Development Facilitation Team (DFT) – Review Comments

Project No: PR-2024-010933 Date: 5/21/2025 Agenda Item: # 6 Zone Atlas Page: J-13

Request: Waiver to DPM Section 7.2(D) and Specifically Table 7.2.29.

Location: 1736 Central Ave SW between Central Ave. and Chacoma Pl SW 2.394 acres

Plat of Garcia's Kitchen Redevelopment Being a Replat of Lots 1 and 2 of Garcia Properties Development and M.R.G.C.D. Tracts 131 and 132 of Property Map No. 38

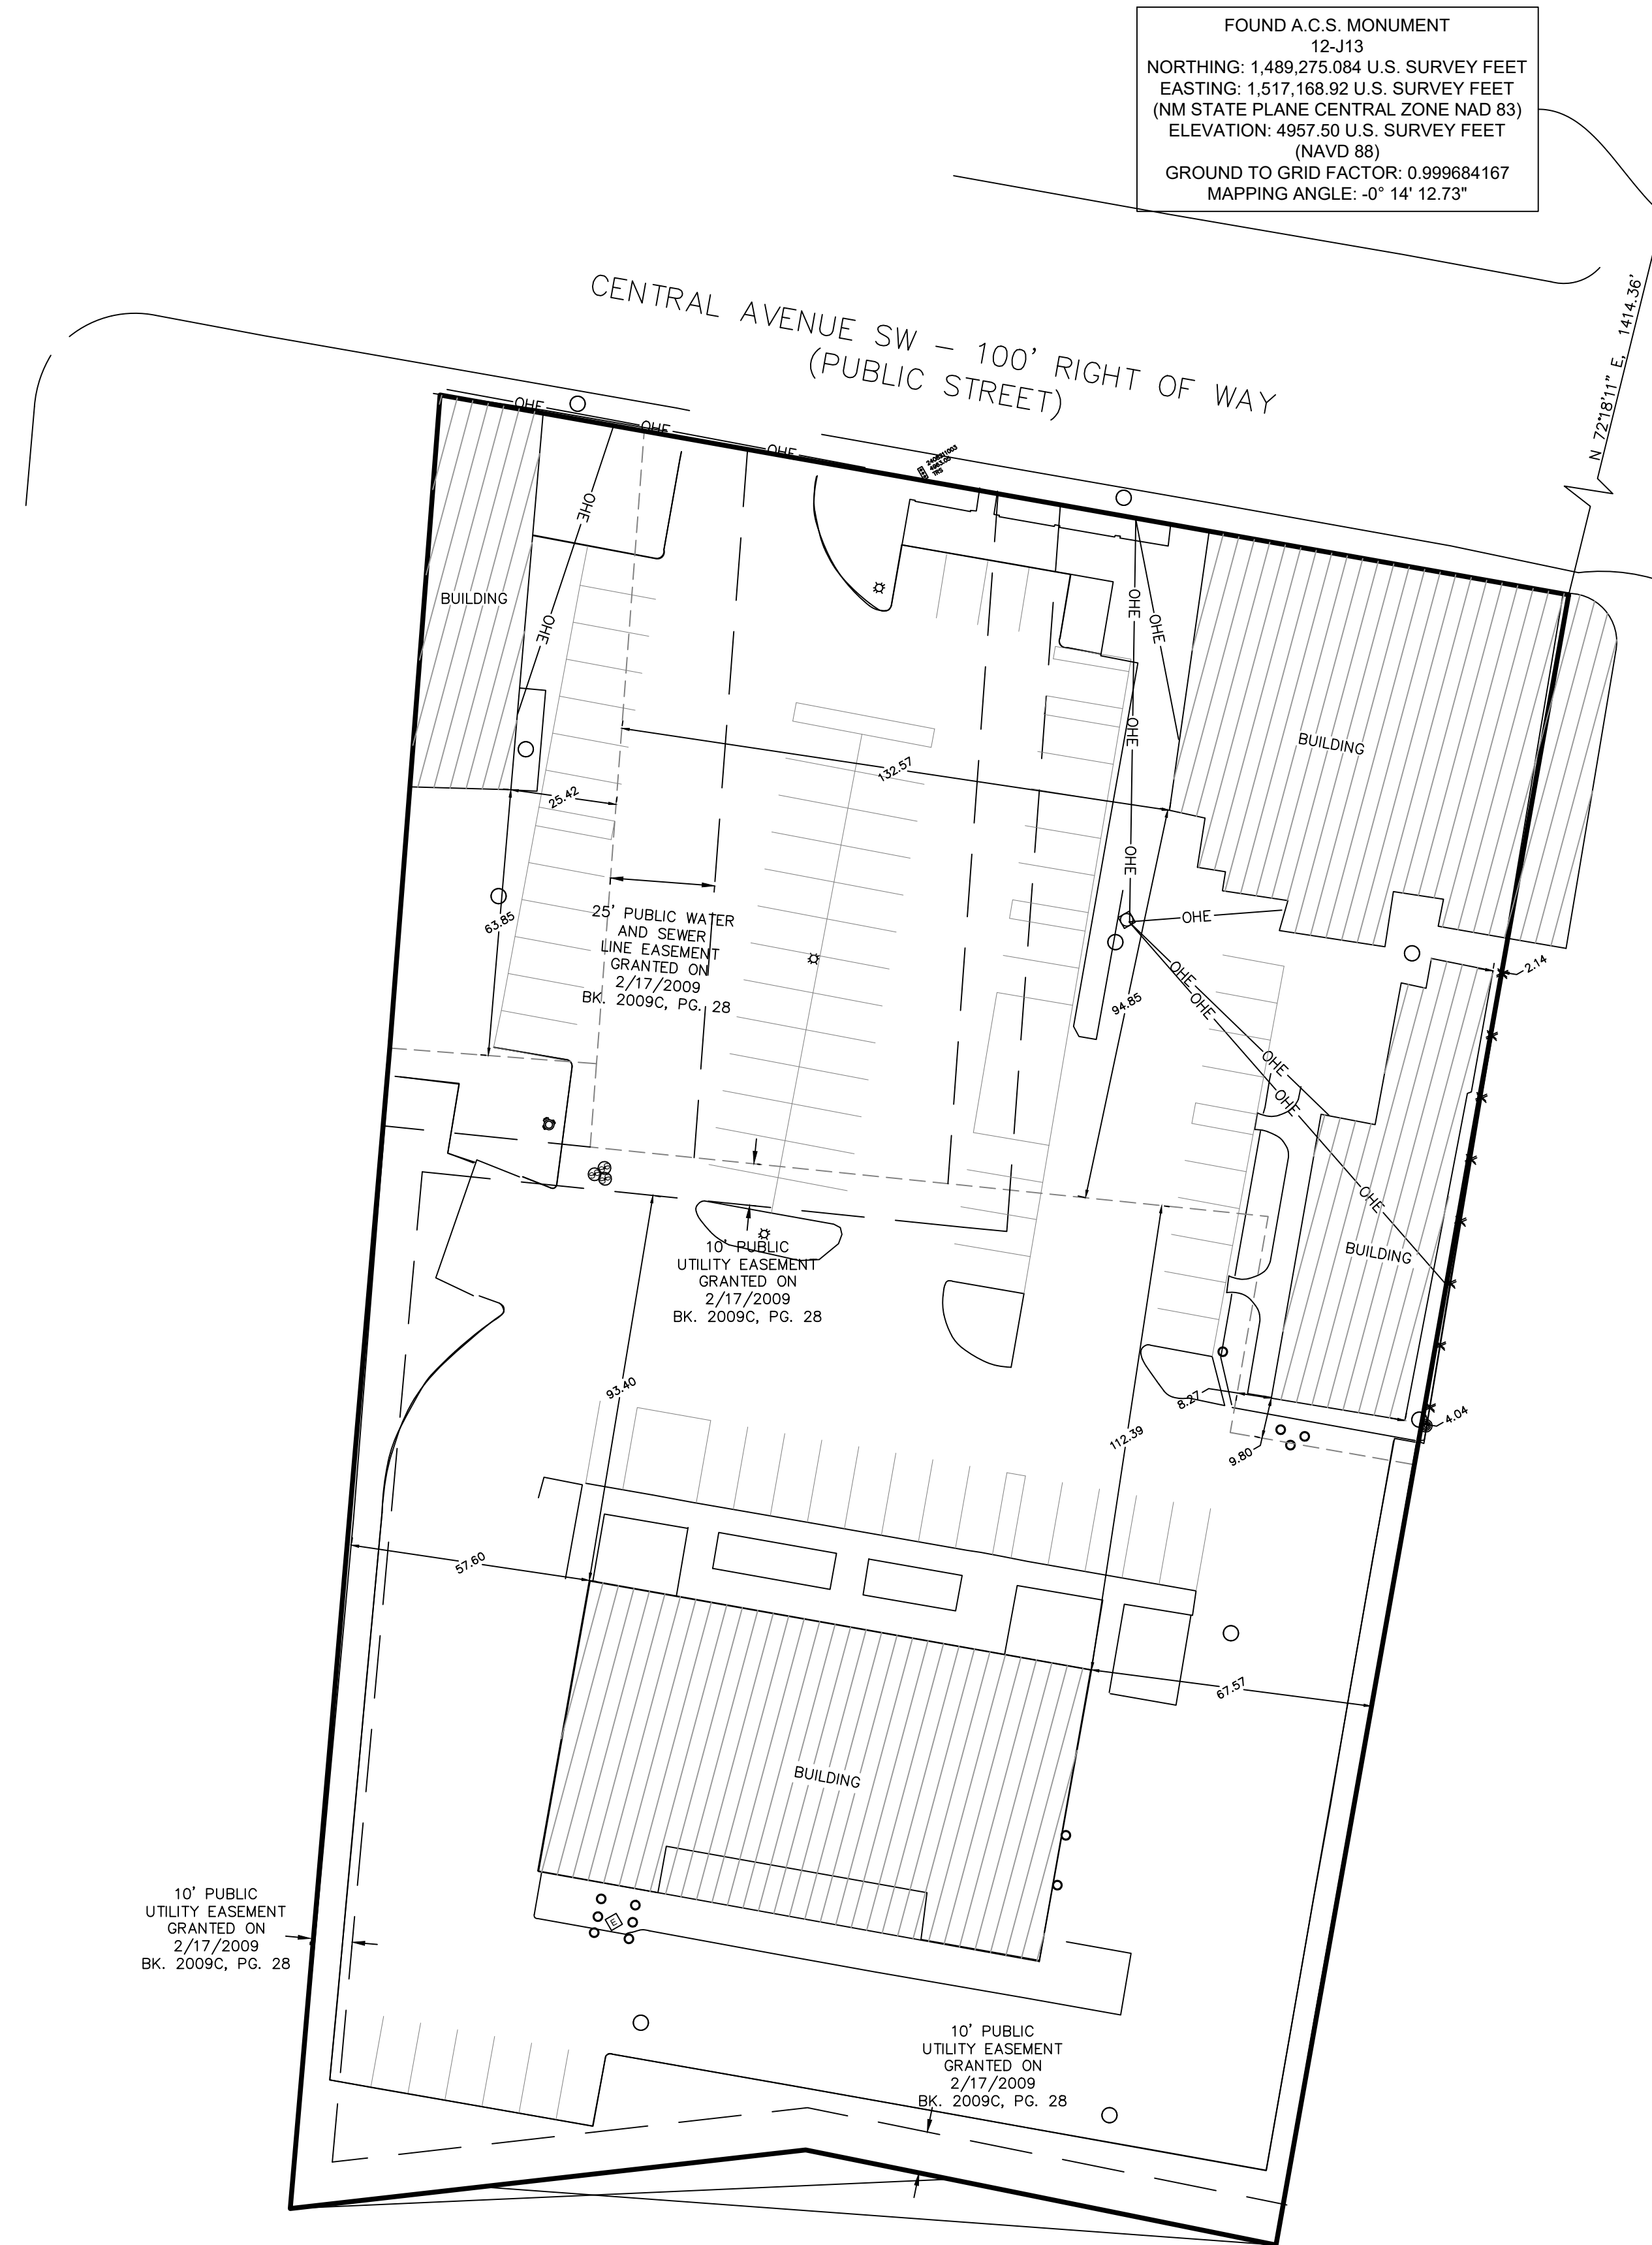
1. Central is a Main Street and requires 10' to 12' sidewalk with a 6' to 8' landscape buffer. Please provide a diagram with existing sidewalk and buffer widths. Your waiver request did not address any of the ten criteria listed in IDO 6-6(P)(3). Unfortunately, all ten criteria must be met to be granted a waiver. Please resubmit with these criteria addressed.
2. An approved TCL will be required prior to site plan or building permit. Also, please fill out and submit a Traffic Scoping Form to determine if a traffic study will be required.

- A note must be added to the Plat regarding the request (approval) of this waiver from the Development Hearing Officer (DHO) to allow narrower sidewalk along Central Ave. NW.
- Per Table 6-4-3 of the IDO, a Sidewalk Waiver expires within 1-year if not platted and expires with associated Site Plan if approved by the DHO.
